Our ref: NO/2018/110834/03-L01
Your ref: 3/2018/0423
Date: 24 August 2018

**NON-MATERIAL AMENDMENT TO APPROVED OUTLINE PLANNING PERMISSION
3/2012/0179 (OUTLINE APPLICATION FOR A RESIDENTIAL DEVELOPMENT FOR
THE ELDERLY, COMPRISING OF 37 BUNGALOWS AND 40 RETIREMENT
APARTMENTS) TO ALLOW VARIATION OF CONDITIONS 15 AND 19 TO ALLOW
THE FORMATION OF THE SITE ACCESS TO TAKE PLACE BEFORE THE
COMPLETION OF THE FLOOD COMPENSATION SCHEME**

LAND AT ACCRINGTON ROAD, WHALLEY, CLITHEROE

ROAD ACCESS

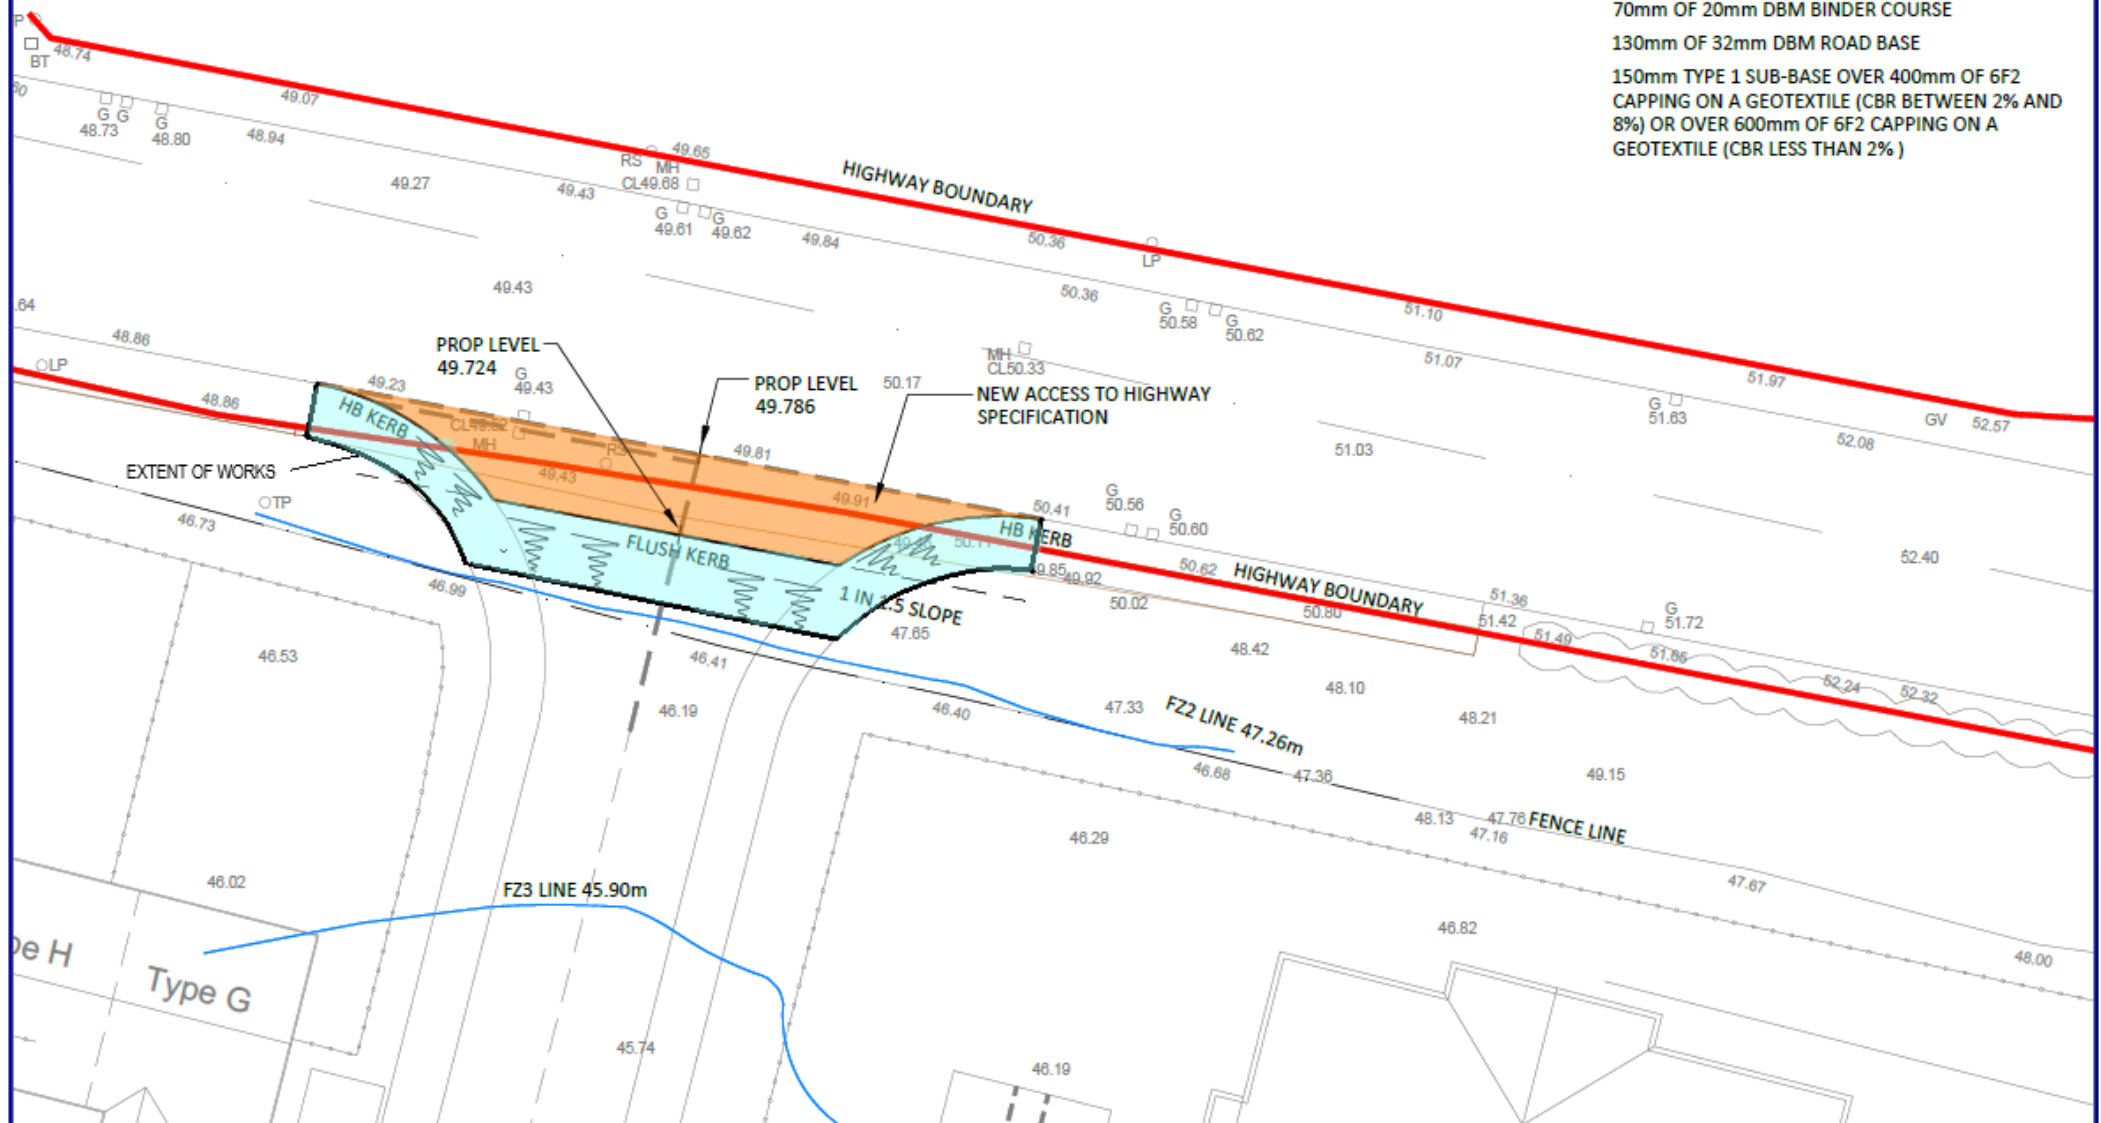
The amended plan referenced 250-125 Rev A "Road Access" by Reford Consulting Engineers Ltd demonstrates that no highway works will take place within the part of the site considered to be at risk of flooding.

If the council is satisfied that Condition 15 can be revised to allow the formation of the site access as shown on drawing number 250-125 Rev A prior to the completion of compensatory flood storage scheme, the highway works as proposed would not be within the floodplain and would not affect flood risk on site.
